SUBMISSION – OBJECTION TO STATE SIGNIFICANT DEVELOPMENT APPLICATION

Application Number: SSD-119133490

Residential Flat Building with Infill Affordable Housing, 40-56 Ourimbah Road, Mosman

Figure 2 Extent of the height variation from highest point of the building (Source: Doroch Architects and Gyde Consulting Markups)

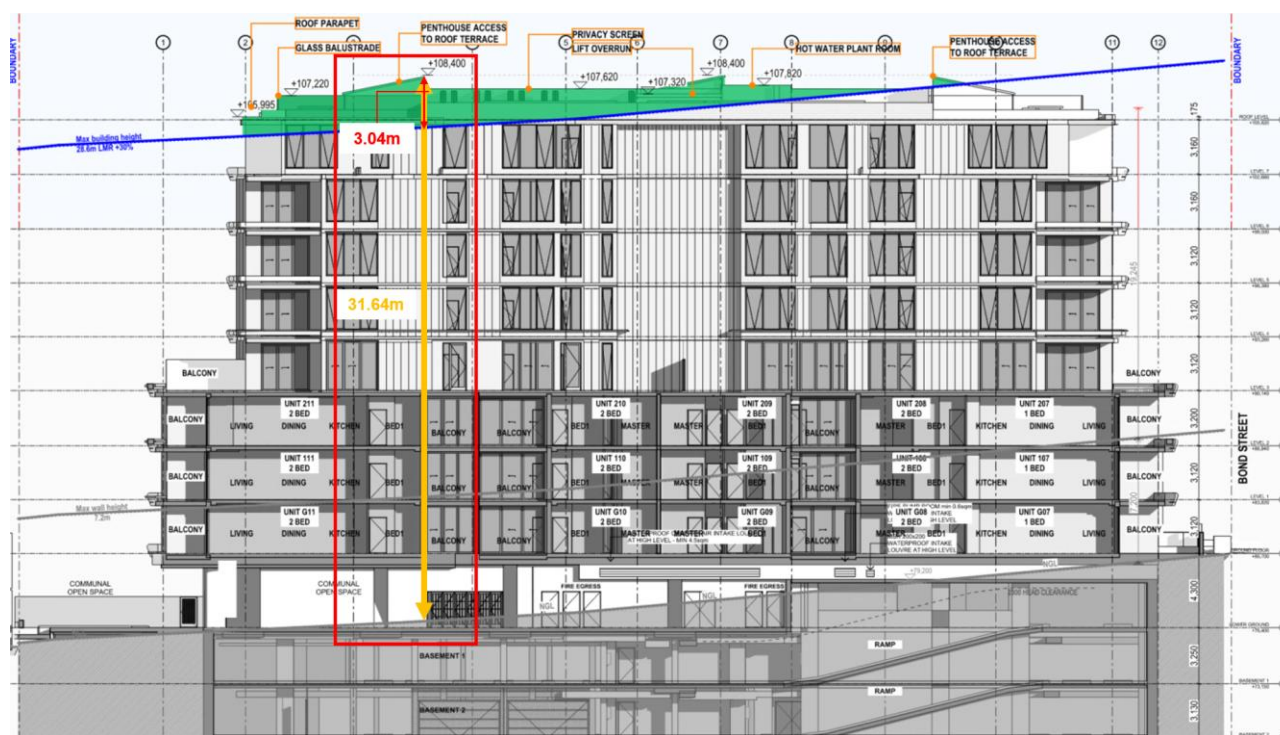
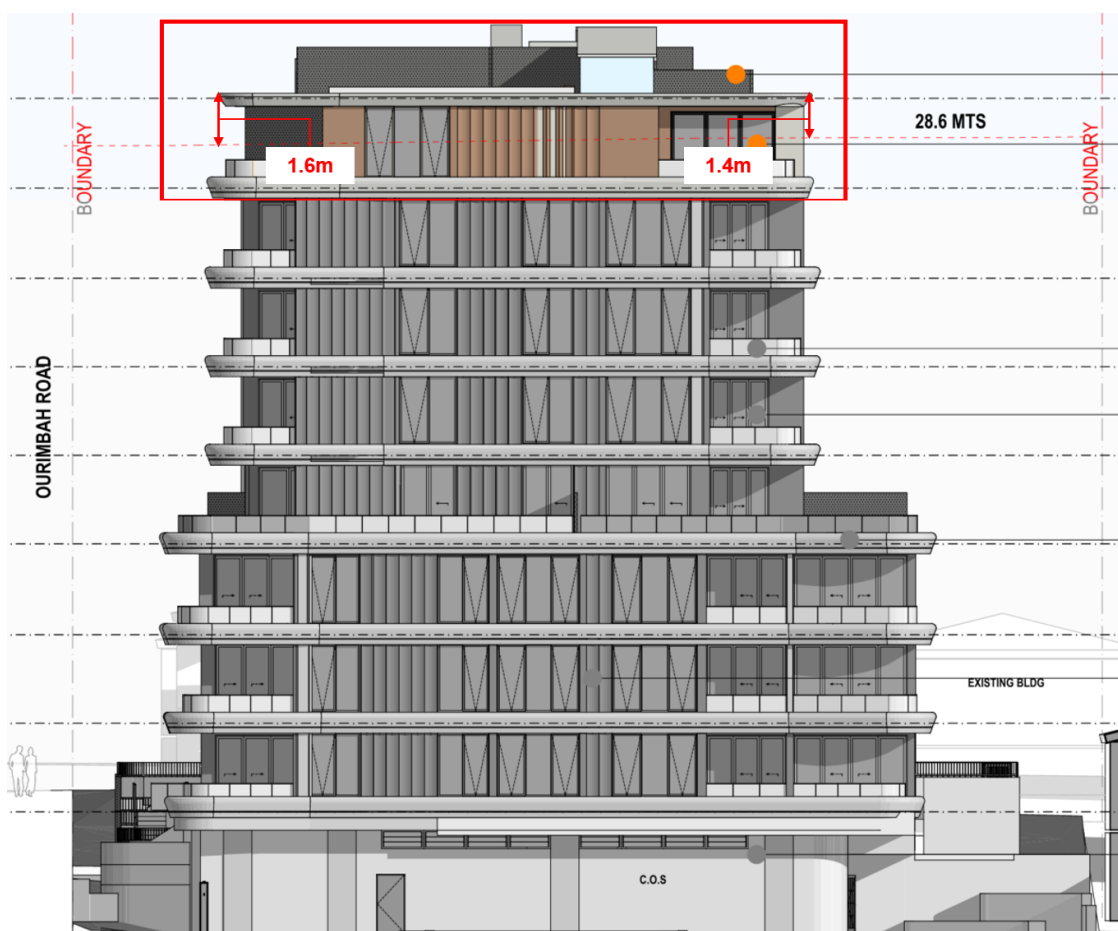
- The EIS states the proposed development has a maximum building height of 31.64m — a variation of 3.04m, or 10.6%, beyond the maximum permissible height of 28.6m, which the applicant's own documents concede requires a Clause 4.6 variation request (EIS Appendix 4) to proceed.

I submit that a development which requires two separate variations to exceed both the height and wall height standards — standards that were only recently set through the LMR rezoning specifically to guide the appropriate scale of development in this area — should not be approved as an exception to the very controls the rezoning was designed to establish. The applicant's own justification does not overcome the fact that Council itself objected to this exceedance and the applicant made no changes in response.

- Refuse consent to SSD-119133490 in its current form; or, in the alternative,
- Require the building height to be amended to comply with the maximum permissible height of 28.6m (or, preferably, the base 22m/6-storey standard contemplated by Section 175 of the Housing SEPP), removing the part 9-storey component;

Table 4 Extracts of the shadow diagrams within existing context (Source: Doroch Architects)

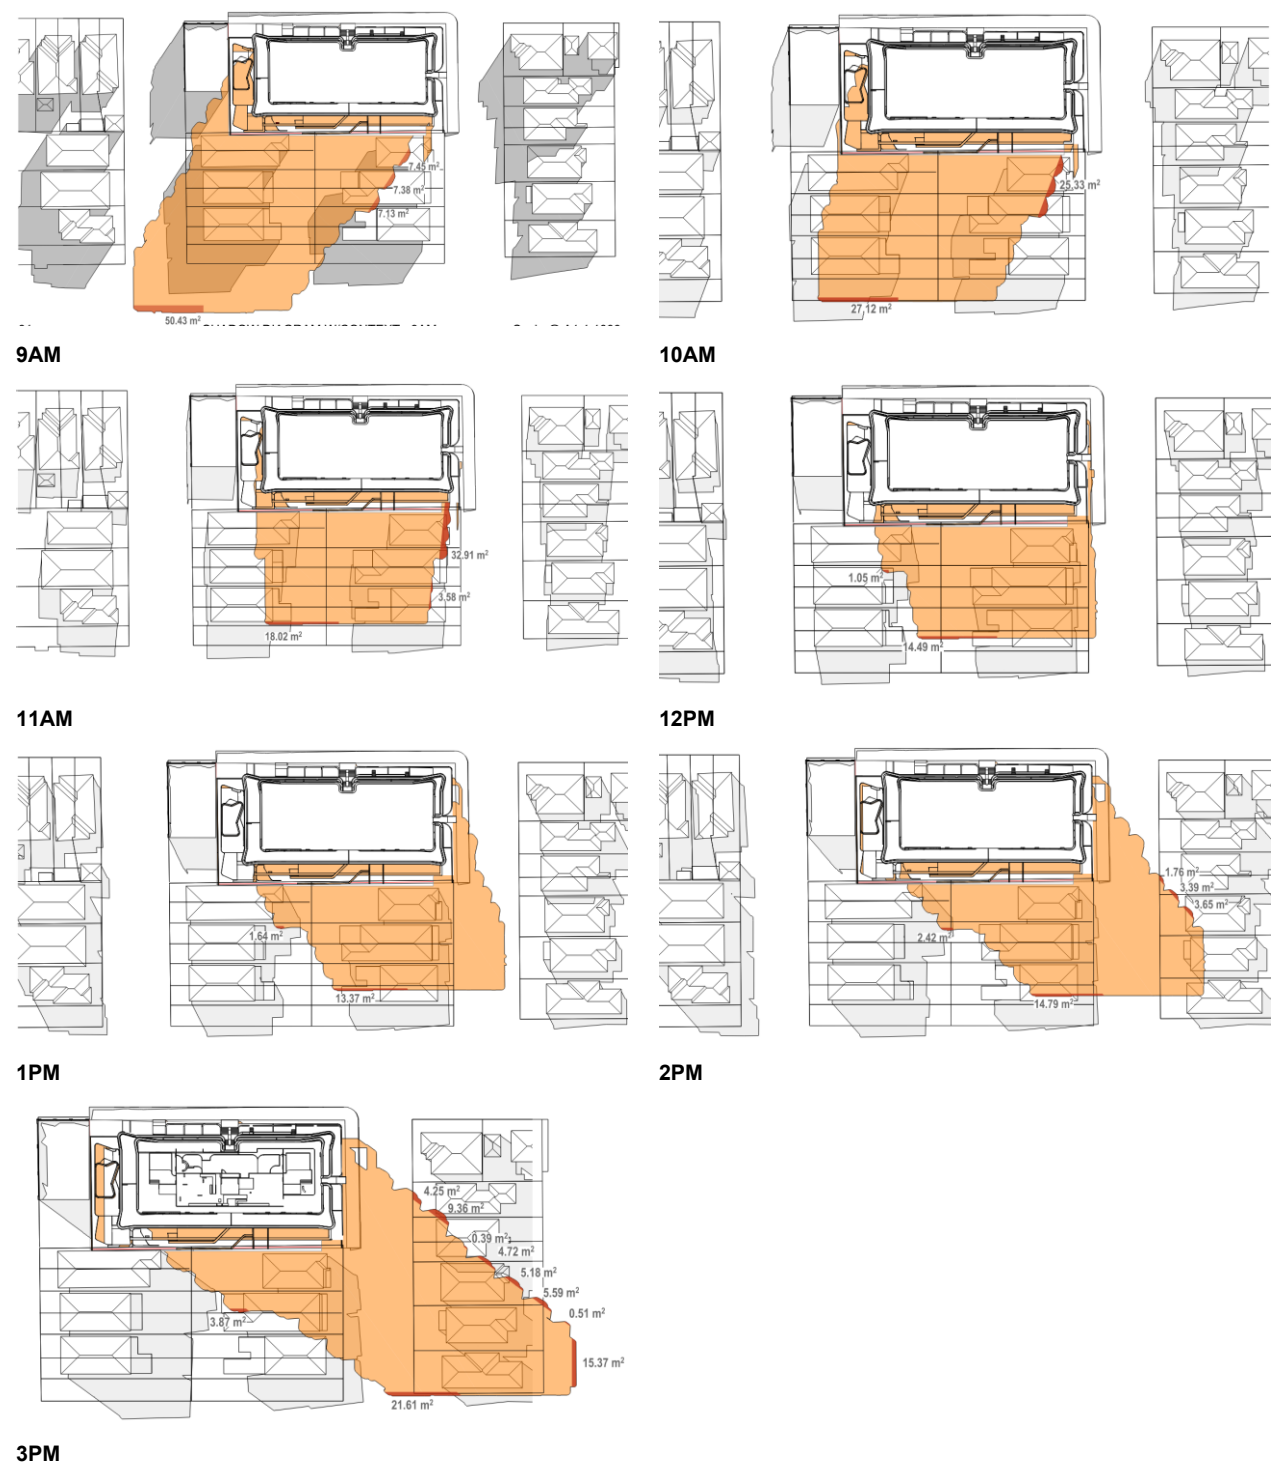
Having reviewed Figure 35 of the EIS ('Shadow diagrams 21st June Winter Solstice – existing surrounding context', prepared by Doroch Architects, page 73), which sets out hourly shadow diagrams from 9am to 3pm and extends to cover the surrounding property lots including my own, I make the following observations. While this figure is prepared at a precinct-wide level of detail rather than addressing my property individually by name, it nonetheless indicates that, on 21 June, the majority of my dwelling remains in shadow until approximately 11am, and my rear yard remains in shadow until approximately 12:30pm. If accurate, this represents a loss of usable morning solar access to both my principal living areas and my private open space for almost half of the assessed 9am–3pm winter solstice window.

- Shadow length at low winter sun angles is primarily a function of building height, not only setback distance. An additional 2 to 3 storeys of height — already conceded by the applicant to exceed the permitted envelope by over 3 metres — will extend the shadow footprint further along Rosebery Street during winter mornings and afternoons than a compliant 6-storey/22m (or even a 28.6m IAH-bonus) building would. Given my own observation that my dwelling and yard remain shadowed until 11am and 12:30pm respectively, this is not a marginal or theoretical impact — it is a substantial reduction in usable winter solar access, consistent with what the exhibited diagrams show even at my property's distance from the site.

- The EIS's narrative discussion of the shadow diagrams concentrates its detailed commentary on the single property immediately adjoining the site to the south, and does not separately quantify or discuss the impact on properties further along Rosebery Street, including mine, despite the diagrams themselves appearing to extend that far.

- I request that the consent authority require the applicant to provide a specific, itemised shadow and solar access assessment for properties affected in Rosebery Street — confirming or correcting the loss of morning sun to my dwelling and rear yard that Figure 35 (page 73 of the EIS) appears to show — and to assess whether this loss is consistent with the objectives of the ADG and the ordinary expectations of residential amenity in the LMR area, rather than leaving this impact undiscussed in the accompanying text.

- Require the applicant to provide a specific, itemised shadow and solar access assessment for properties affected in Rosebery Street, confirming or correcting the loss of morning sun to my dwelling (until approximately 11am) and rear yard (until approximately 12:30pm) that Figure 35 of the EIS (page 73) appears to show, before any determination is made;
